**Oakdale West Industrial Estate (SSD 7348 MOD 2)
Environmental Assessment Requirements (EARs)**

Oakdale West Industrial Estate, Kemps Creek, Penrith (SSD 7348) – Advice in relation to the Environmental Assessment Requirements for proposed Modification 2.

1 SECTION D - PART 1 1 : 250
WAREHOUSE - 1A

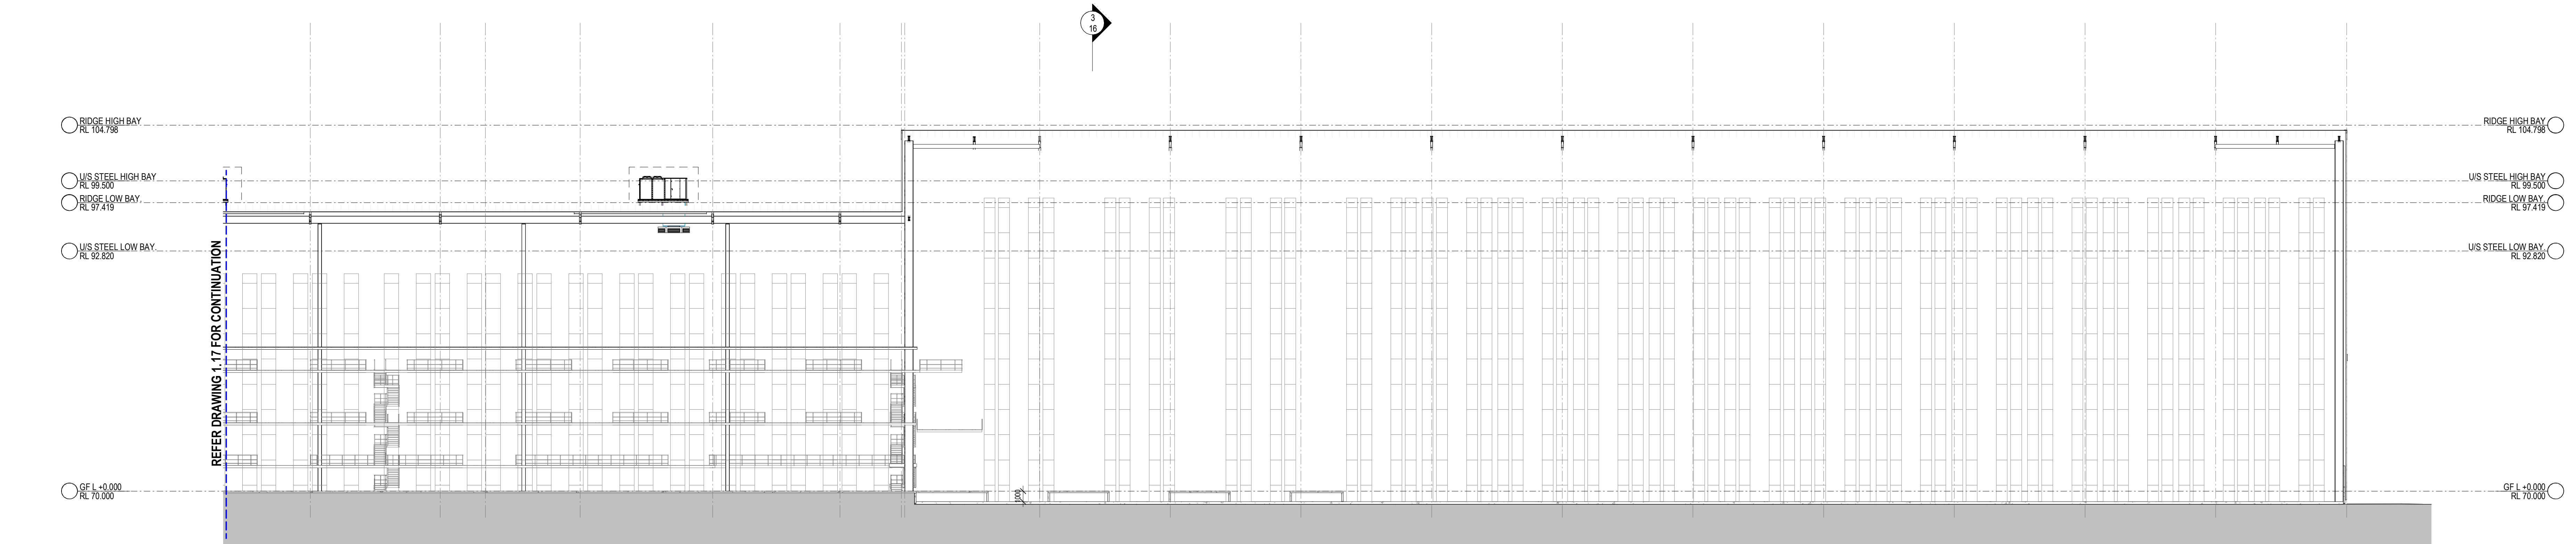
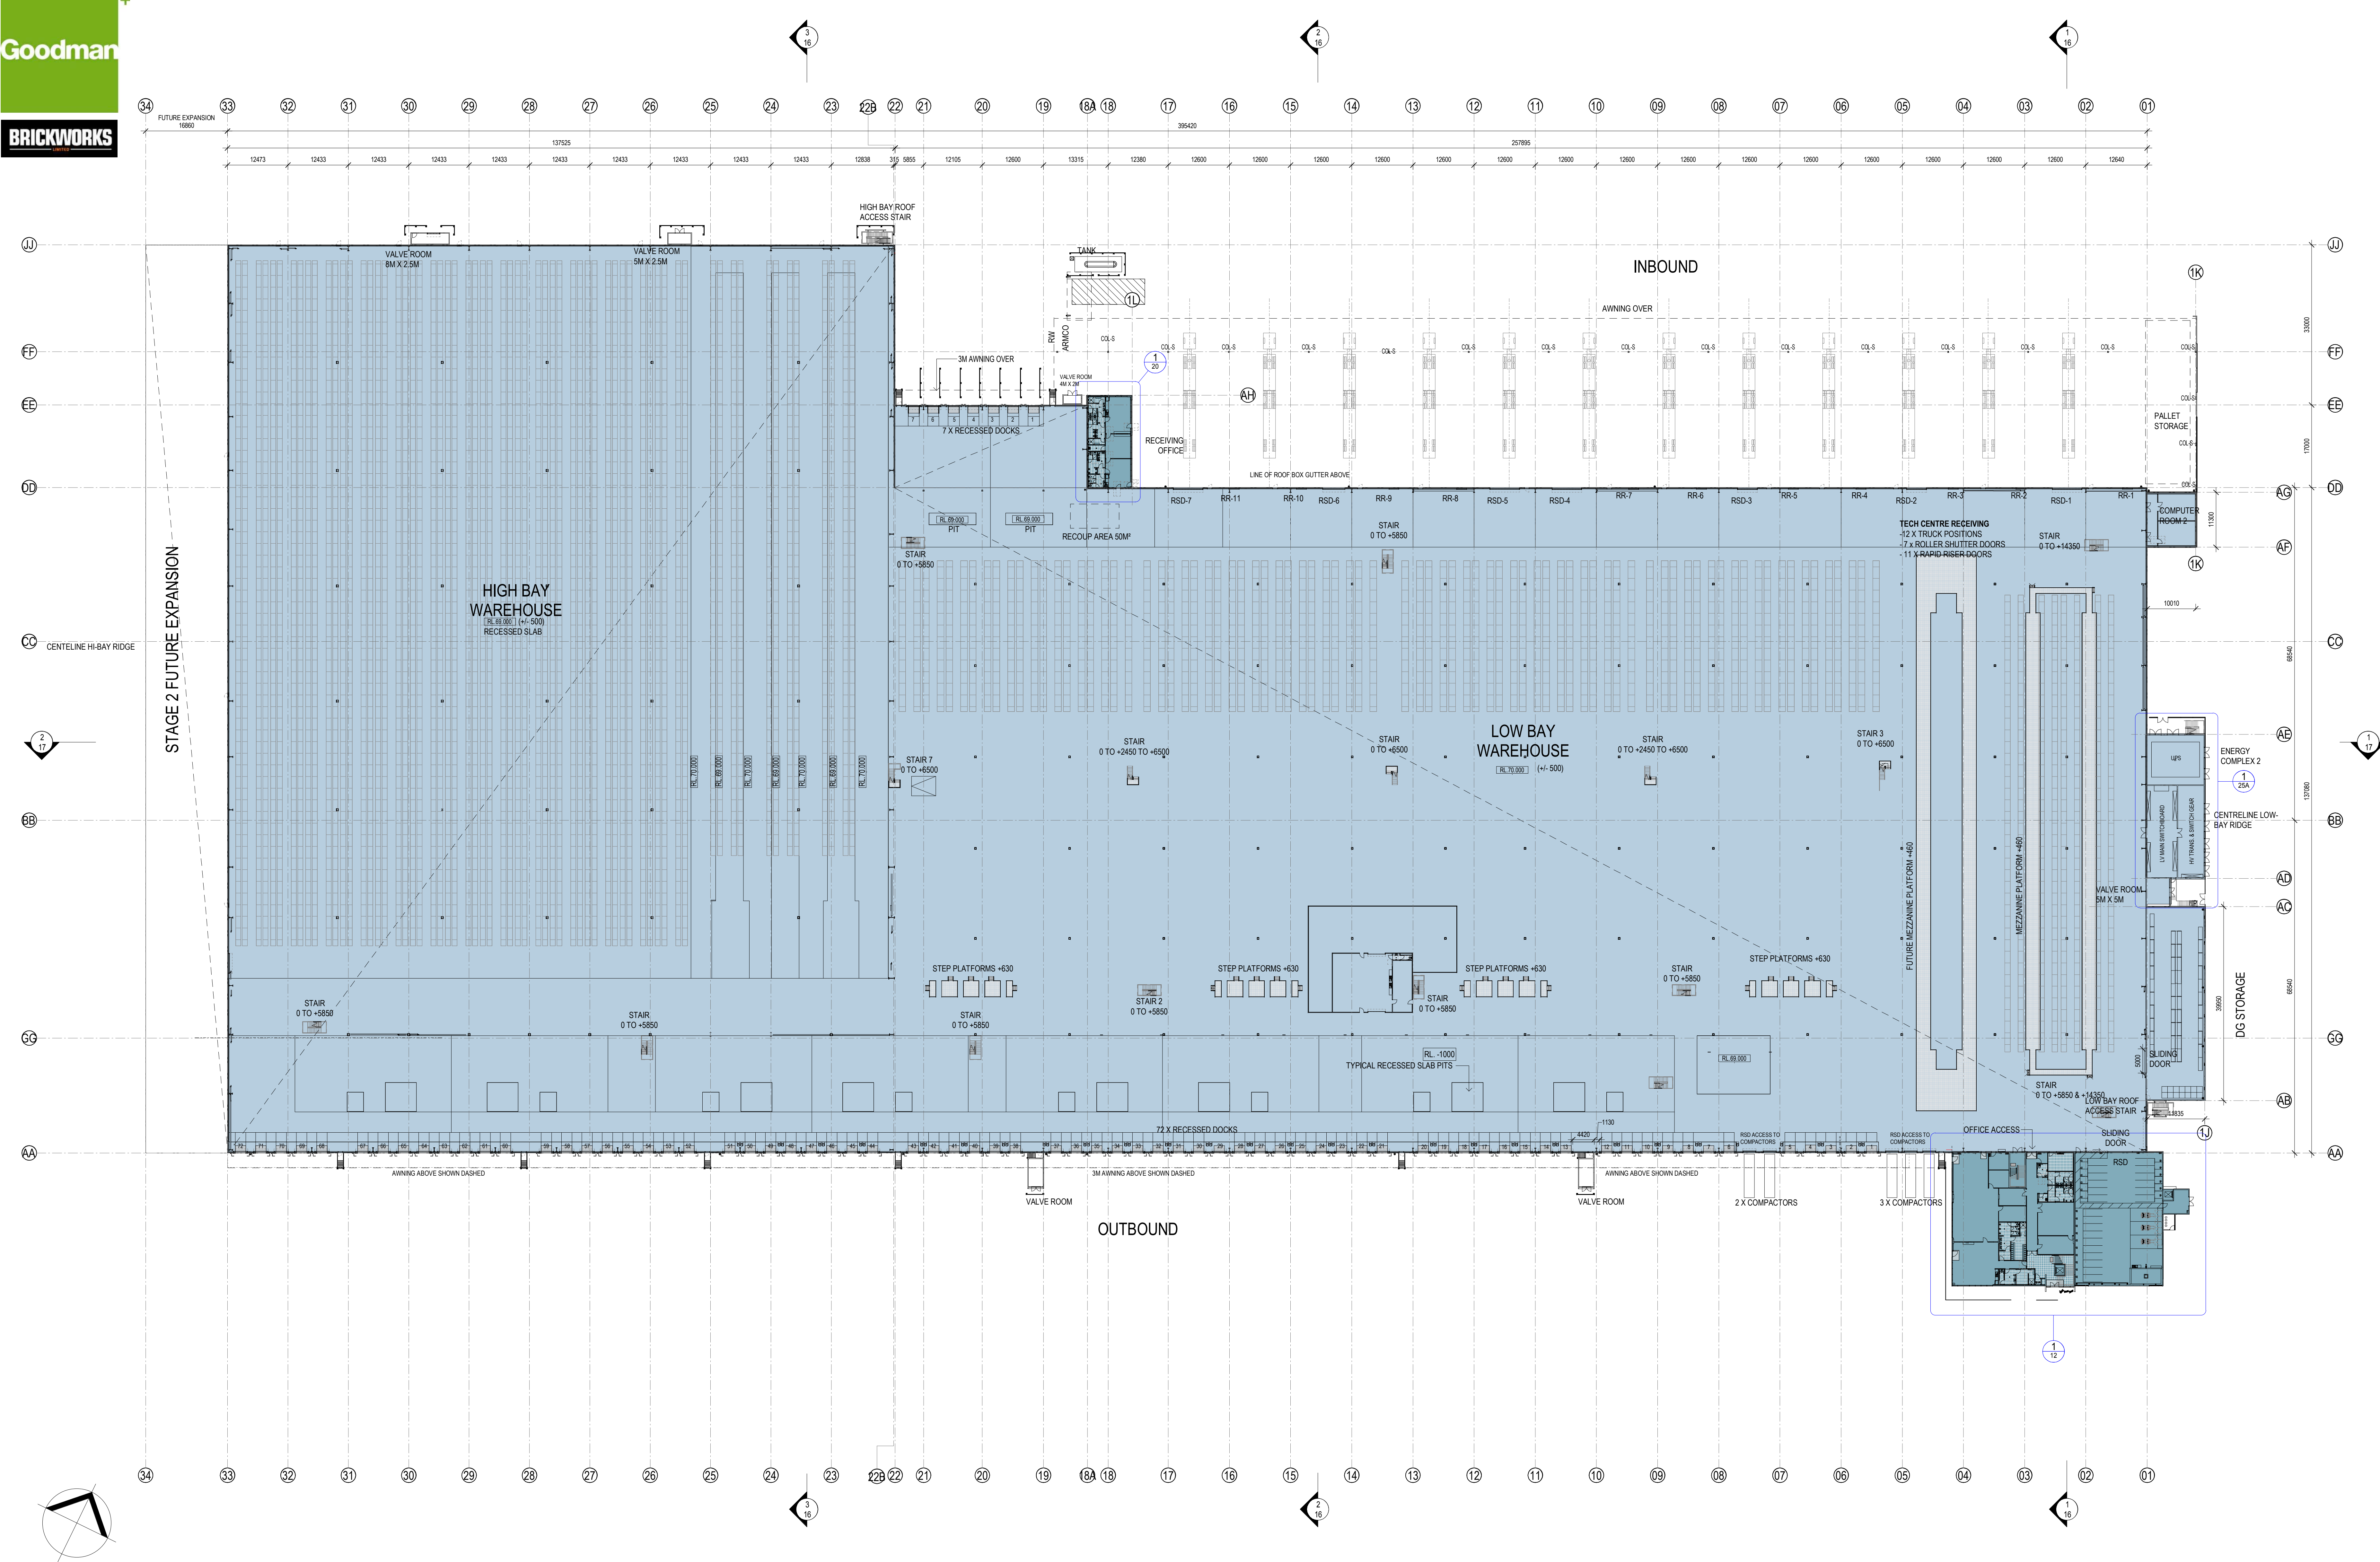
The proposal provides a significant height non-compliance to the applicable DCP for this precinct. The reasoning for the height non-compliance is derived from suggestions for high bay clearance however the height limits in the DCP would have been derived from a character and contextual analysis relevant at the time of its adoption.

Having initial regard to the key test of site suitability noting the DCP height limit, then there is the potential that the site is not suitable for the scale and nature of the proposed development. However, If there is a suggestion that a variation of this extent can be considered, then the application must consider the strategic intentions and reasoning behind the adopted height controls as they currently exist, and then provide analysis for how a variation contextually integrates with the planned outcomes for the entire precinct. Given a site by site departure is not appropriate, the concept plan component should consider and propose suitable alternate building heights for specific nominated sites within the development based on lot size, lot depth and overall orientation. If it is deemed that the DCP height limits are no longer reasonable or suitable contextually, the determination of the concept plan amendment should establish what heights, the consent authority deems to be suitable and reasonable based on a precinct wide analysis.

Given the extent of building height variation, and the contextual analysis that is necessary to underpin this extent of variation, it is recommended that an urban design review panel processes be undertaken. While this is not necessarily typical of industrial and commercial development, the variations sought and massing of the proposal is considered to warrant this level of contextual consideration and demonstration of design quality (if not design excellence). It is recommended that the State Design Review Panel be afforded consideration of this proposal as a development of this scale would be typically considered through Council's Urban Design Review Panel, where Council was the applicable consent authority. This review could consider the built form outcomes proposed but also consider the suitability of the contextual analysis that supports the request for height variation and how changes to height should be considered across the precinct as a whole.
